Preliminary Signage and Pavement Marking Plan

Rollin' Ridge: Filing 1

Construction Drawings_V3.pdf Markup Summary

Pavement Marking and Sign Plan for Construction
Rollin' Ridge Filing 1
Cherry Crossing Drive (Part 1 of 2)

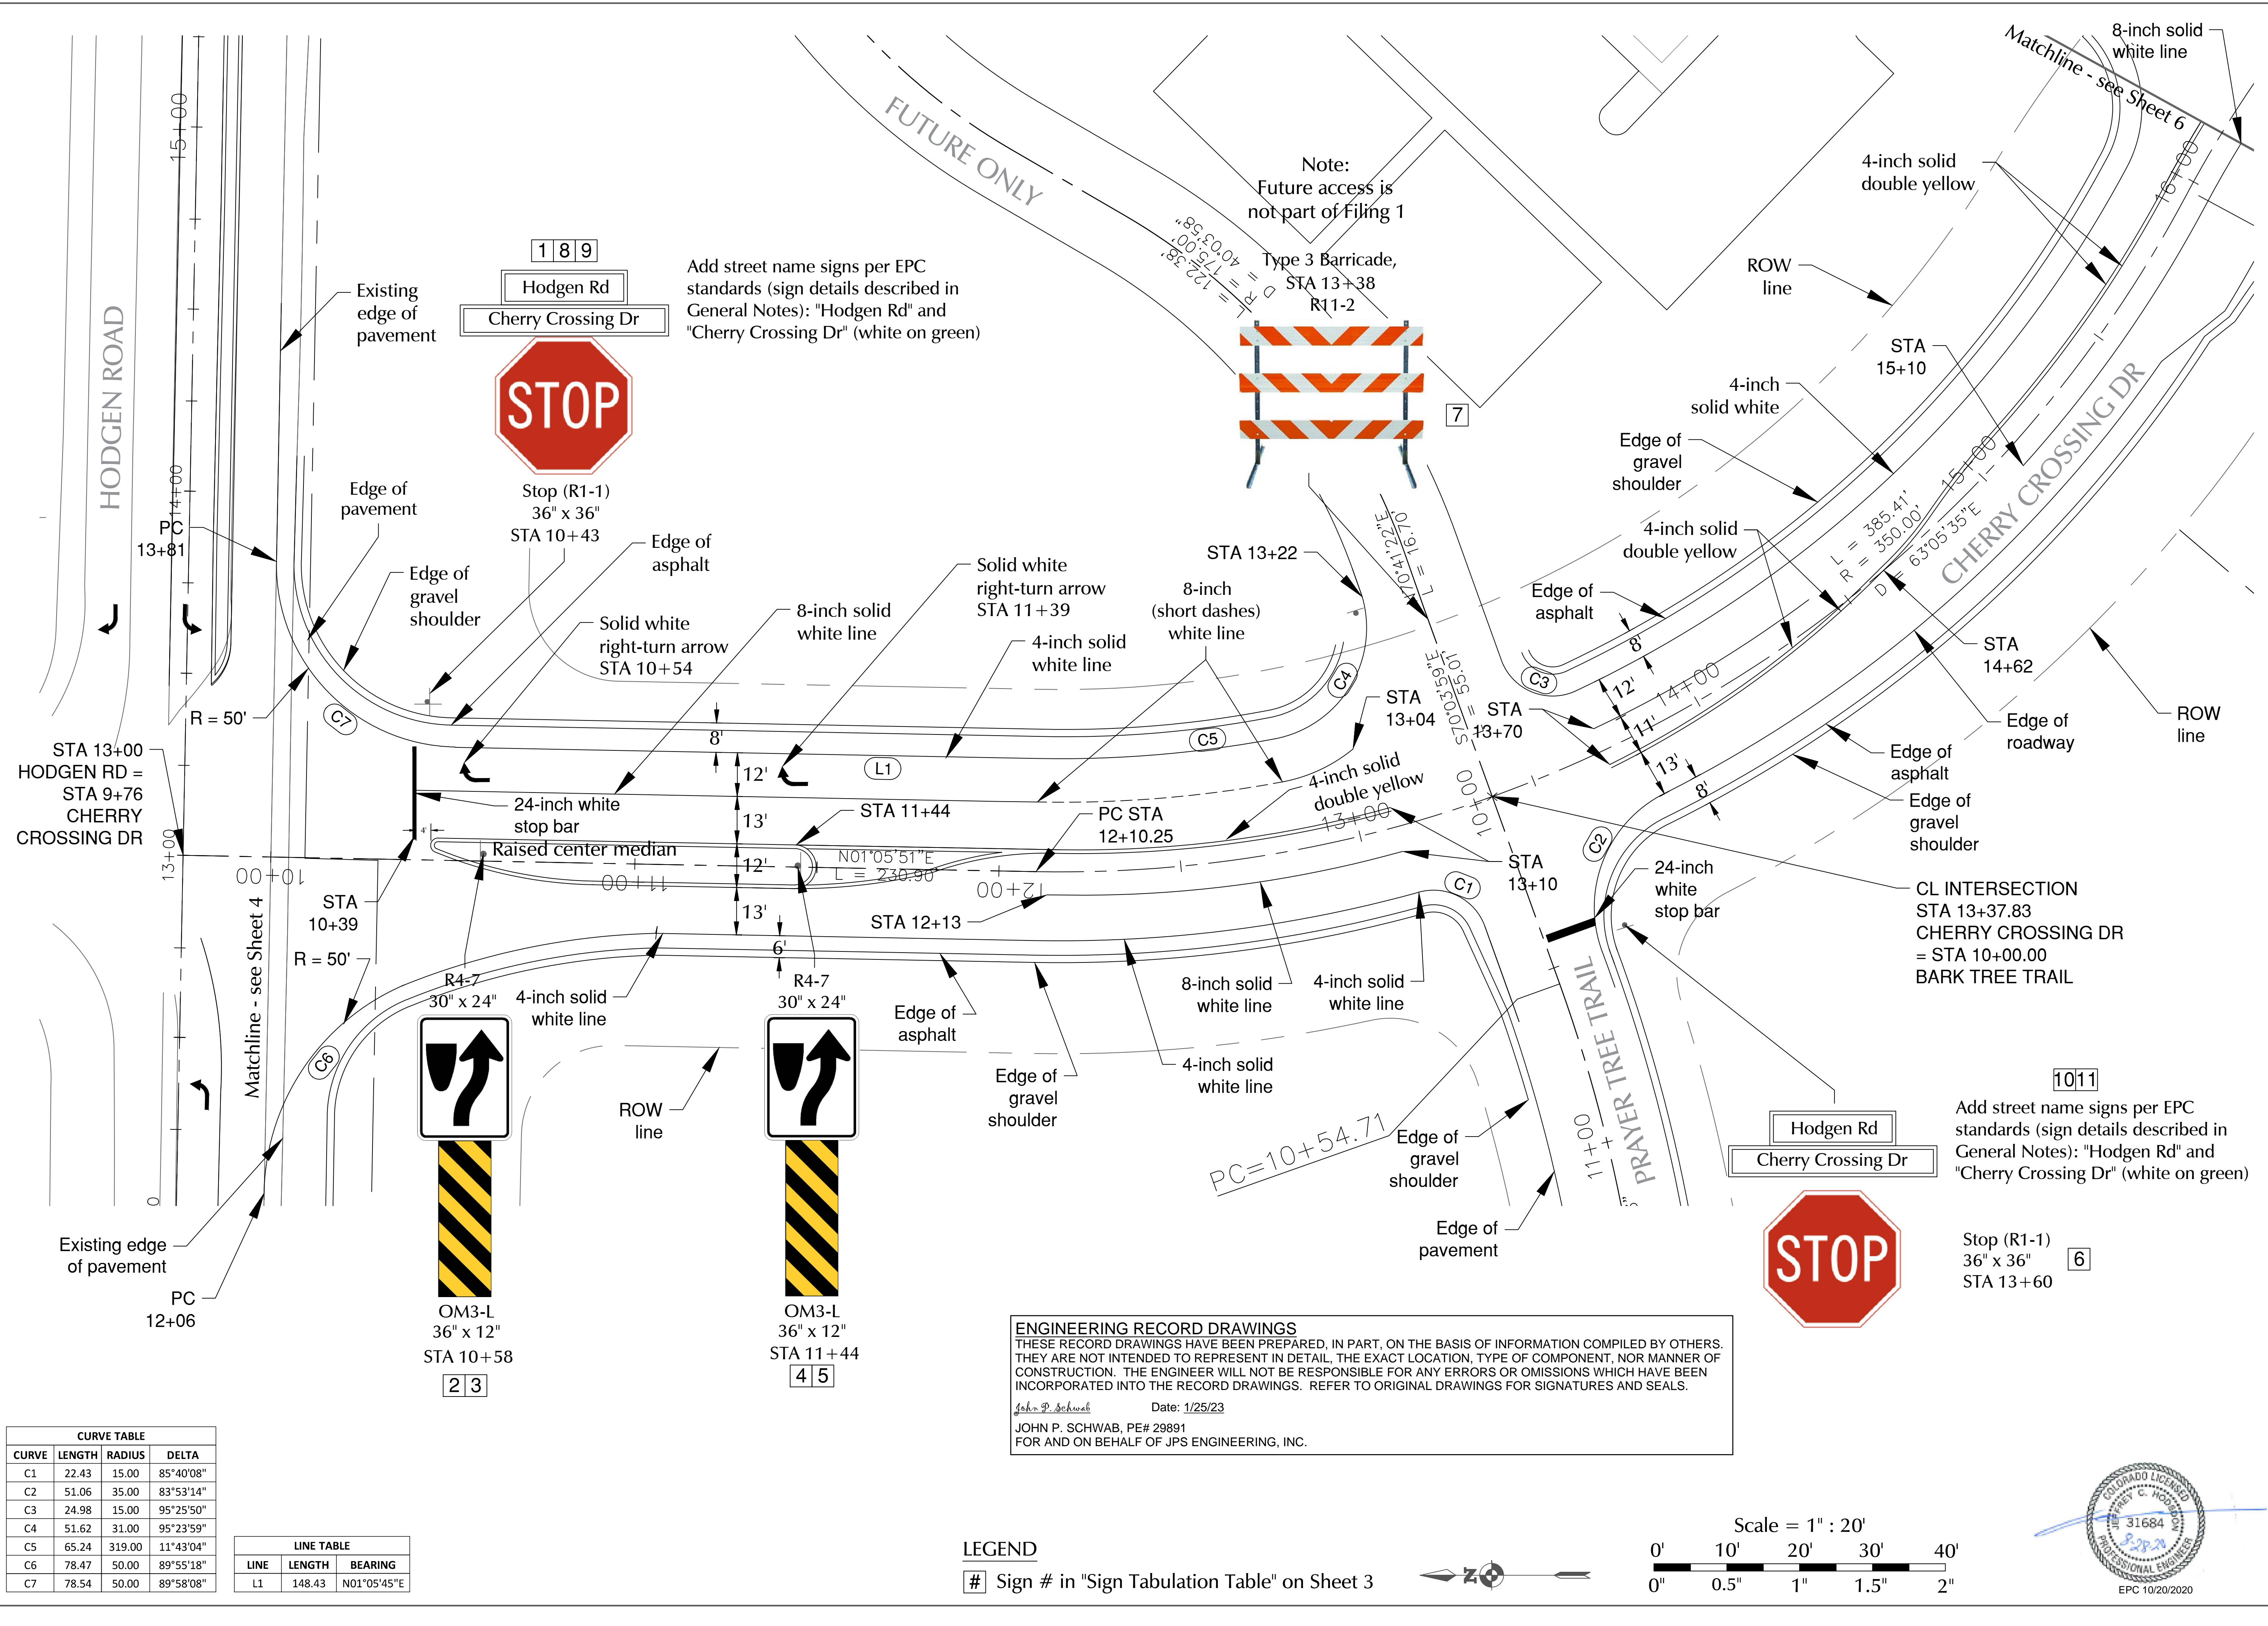
Google maps shows a sign. Show all existing signs and label

include street name sign

Include street name sign

Label thee station for the PT/PC.

Provide station equation for the Hodgen and Cherry Crossing Dr centerline station.

Provide street name
